Laurie Leader - Re: BP#2015-00551 55 Romasco Lane - Plan review comments

From: Jeremy Fink <jfink2000@gmail.com>
To: Laurie Leader <LRL@portlandmaine.gov>
Date: 4/28/2015 8:29 PM
Subject: Re: BP#2015-00551 55 Romasco Lane - Plan review comments
CC: Raymond Ouellette <rayouellettecc@gmail.com>
Attachments: A1 Cross Section.pdf; A4 Proposed Floor Plan.pdf; A6 Window and Door Schedule.pdf

Drawing file: 1. Original Plans / A1 Cross Section.pdf

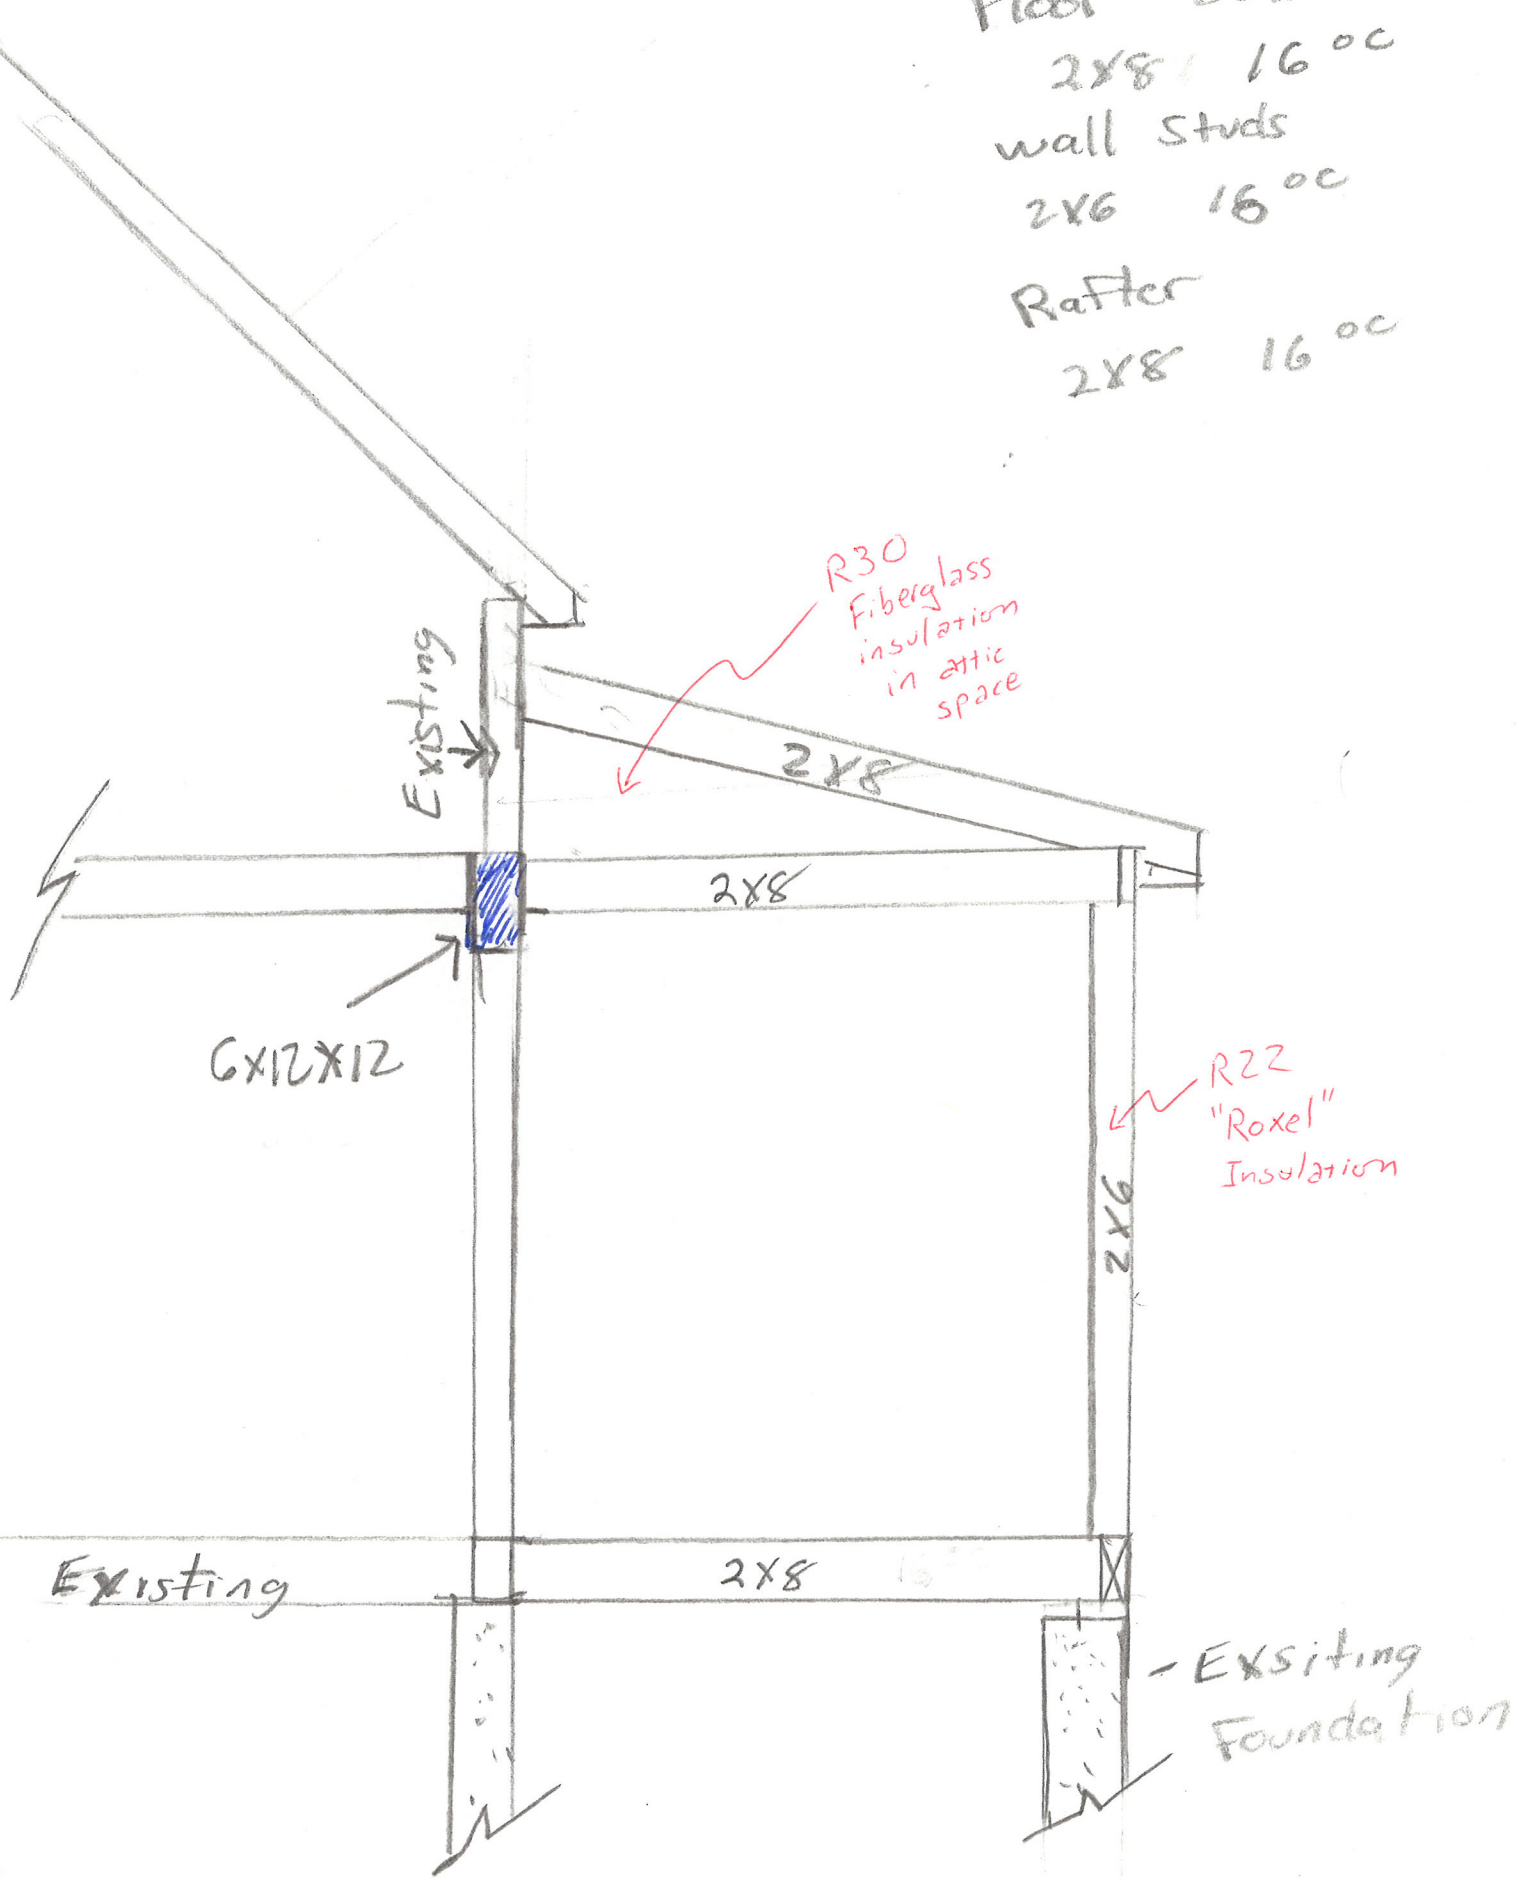
A1 - Cross Section

This wall section has been updated with sizes and spacings for the studs, rafters and joists, R-values and sheathing thicknesses. The new dormer will be attached to the existing house with a 2x12-inch deep ridge pole. The addition will have a one piece rubber roof.

A4
REV. A

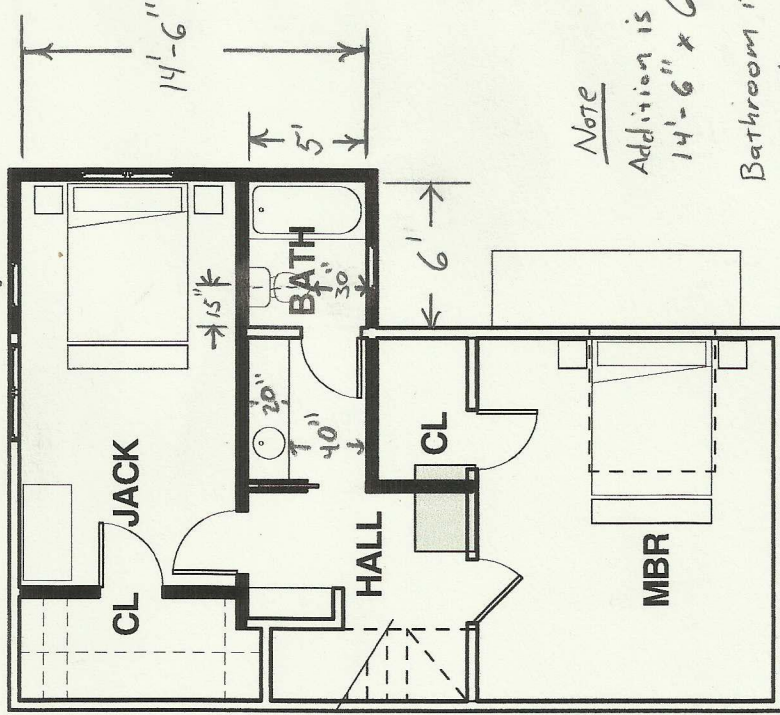
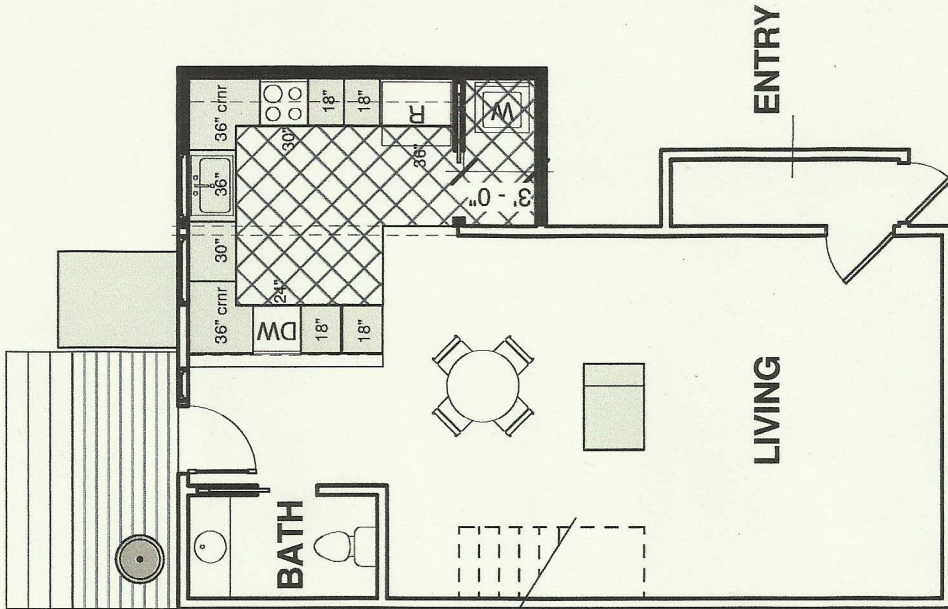
A4 - Proposed Floor Plan

This drawing has been updated with overall dimensions for the new dormer footprint and dimensions for the bathroom showing the R307.1 fixture clearances. The bedroom egress window has been labeled.
